From: Clerk [REDACTED]
Sent: 09 January 2020 10:08
To: Raymond Cole <Raymond.Cole@arun.gov.uk>
Subject: RE: BN/122/19/EIS

Barnham and Eastergate Parish Council's Planning & Environment Committee considered the above application at the meeting held on 7th January. However the short timescale on response and the fact it was over the Christmas and New Year period made it difficult for a full and proper review of the document to be undertaken and discussed. However, those who had been able to find some time to look at the document raised the following issues/comments and asked me to forward them to you for consideration moving forward.

Project: BARNHAM ROAD, EASTERGATE
Title: SITE LOCATION PLAN

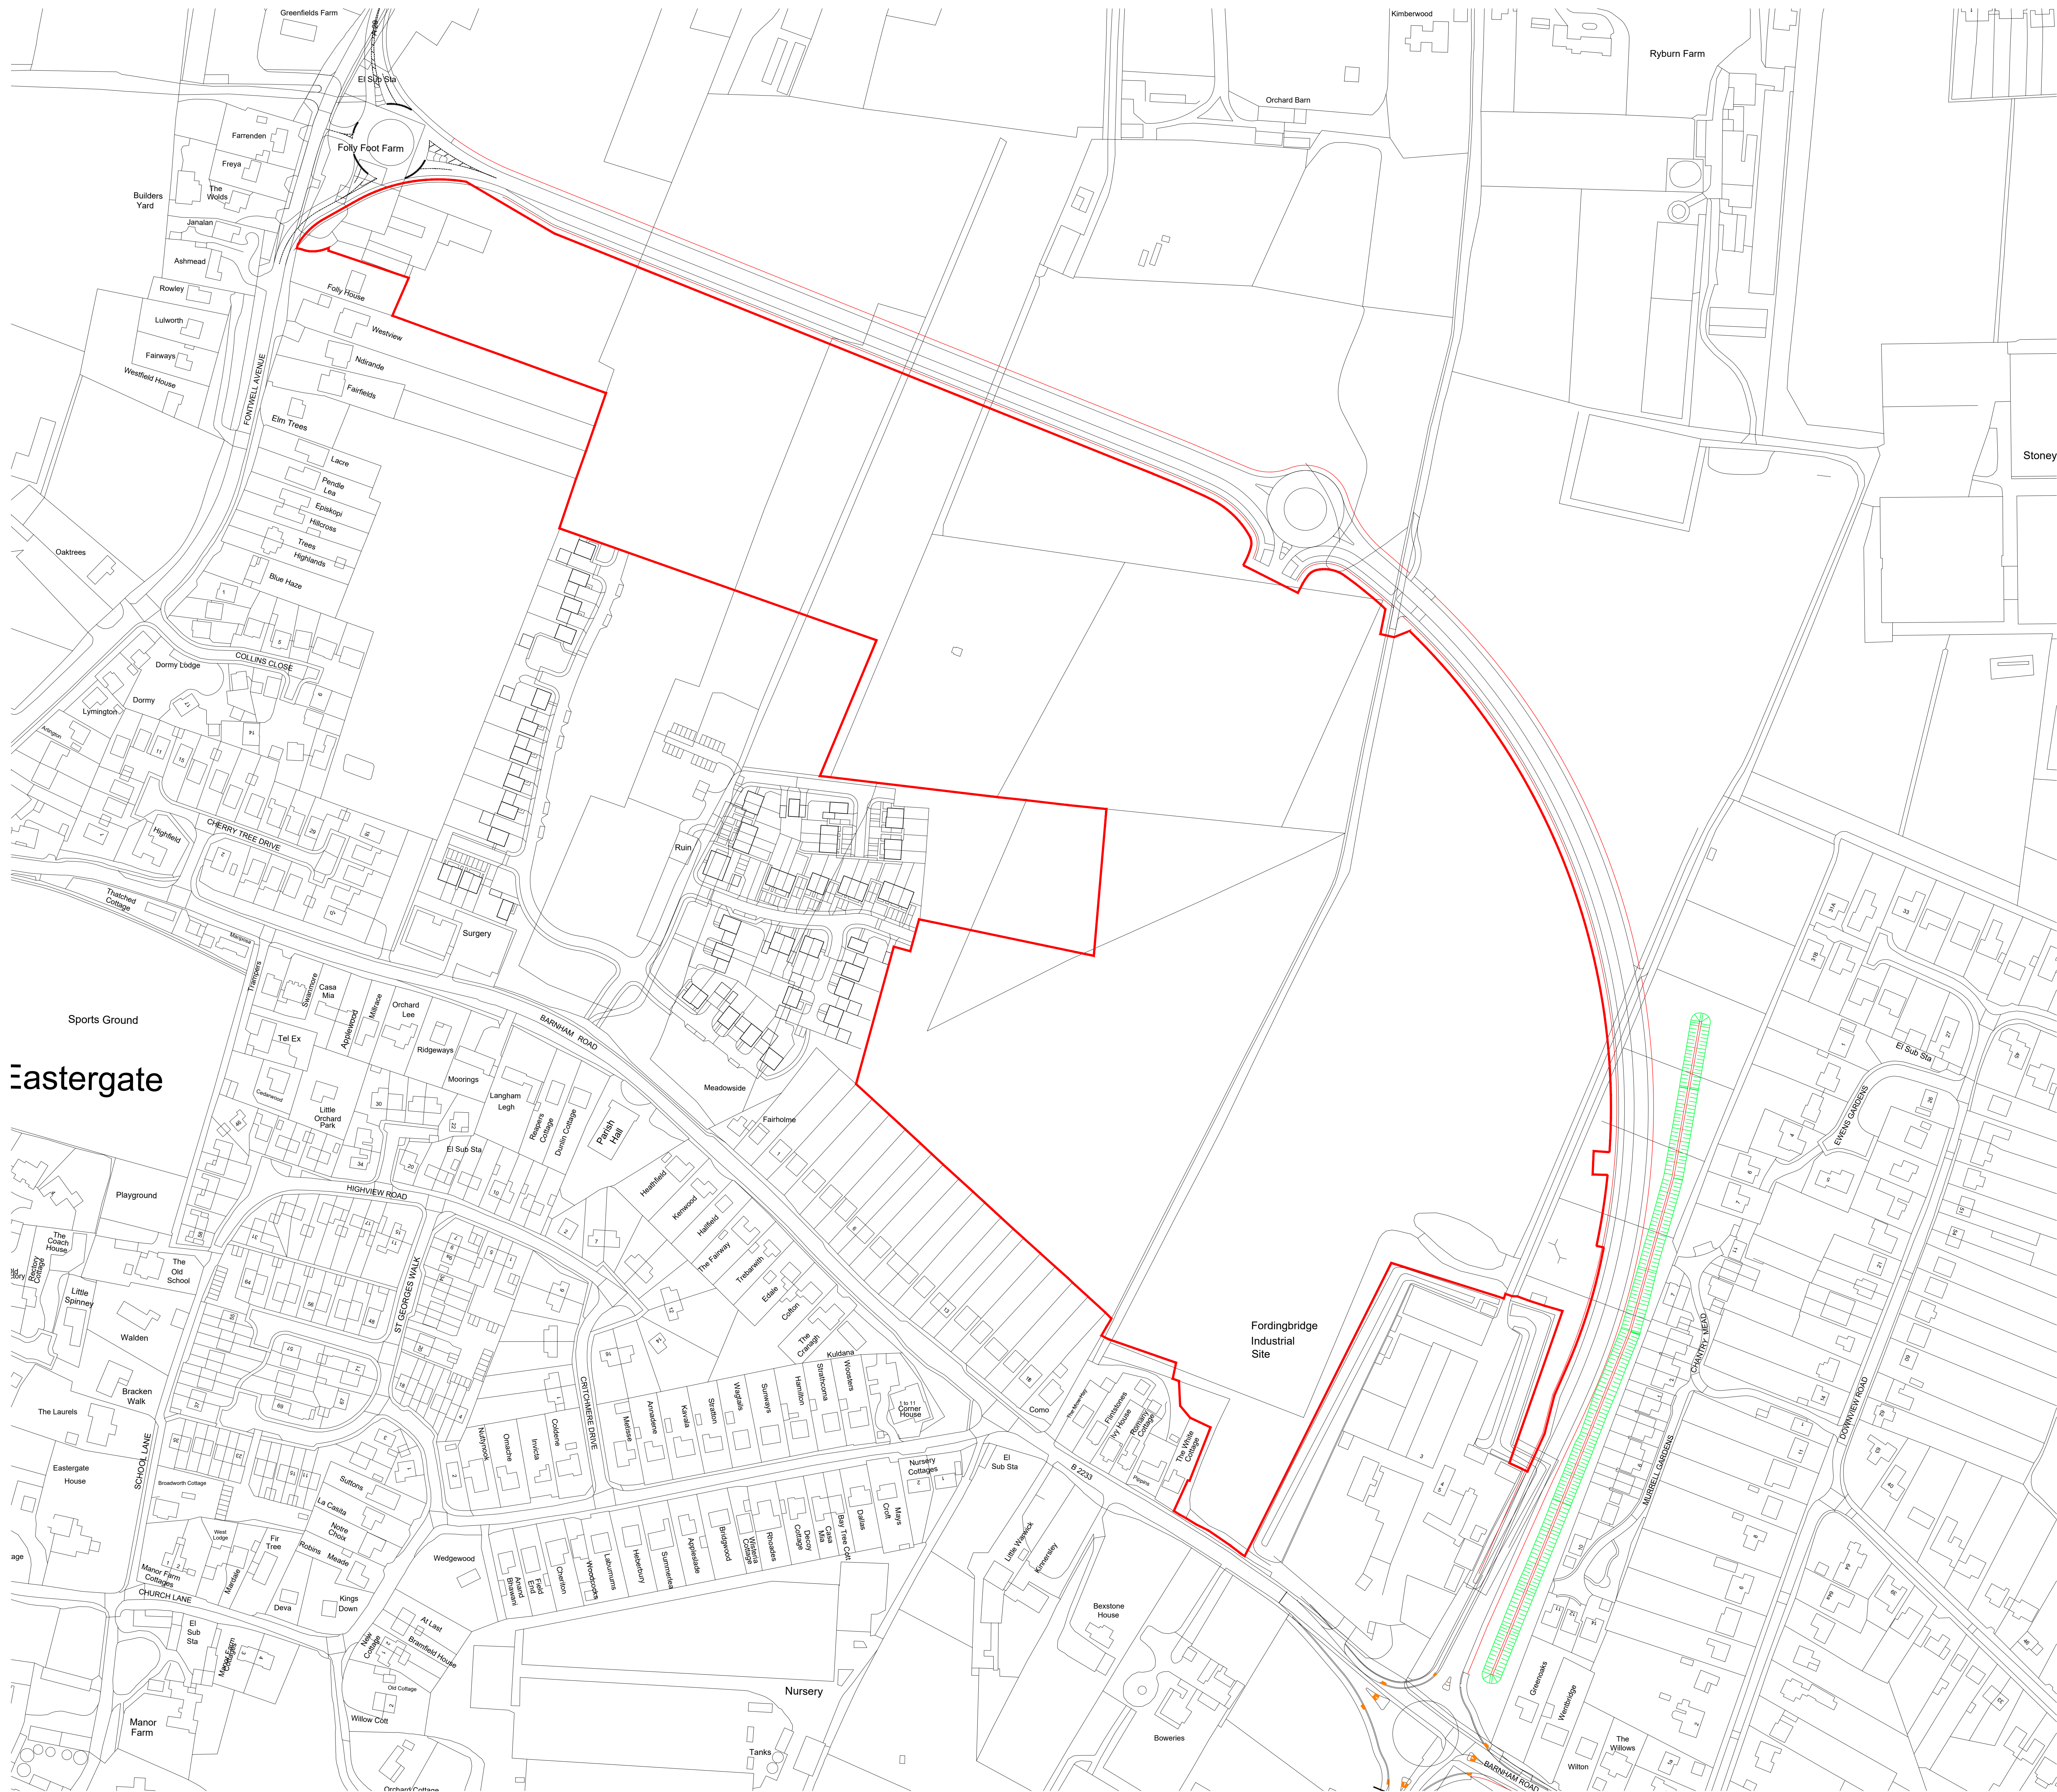
On the map it is not clear if the footpath near the roundabout is routed under the road or over

The green gap needs to be maintained and it is not clear whether or not that will be the case.

There is a sphere shape behind the industrial estate on the Barnham Road and it is unclear what that feature is.
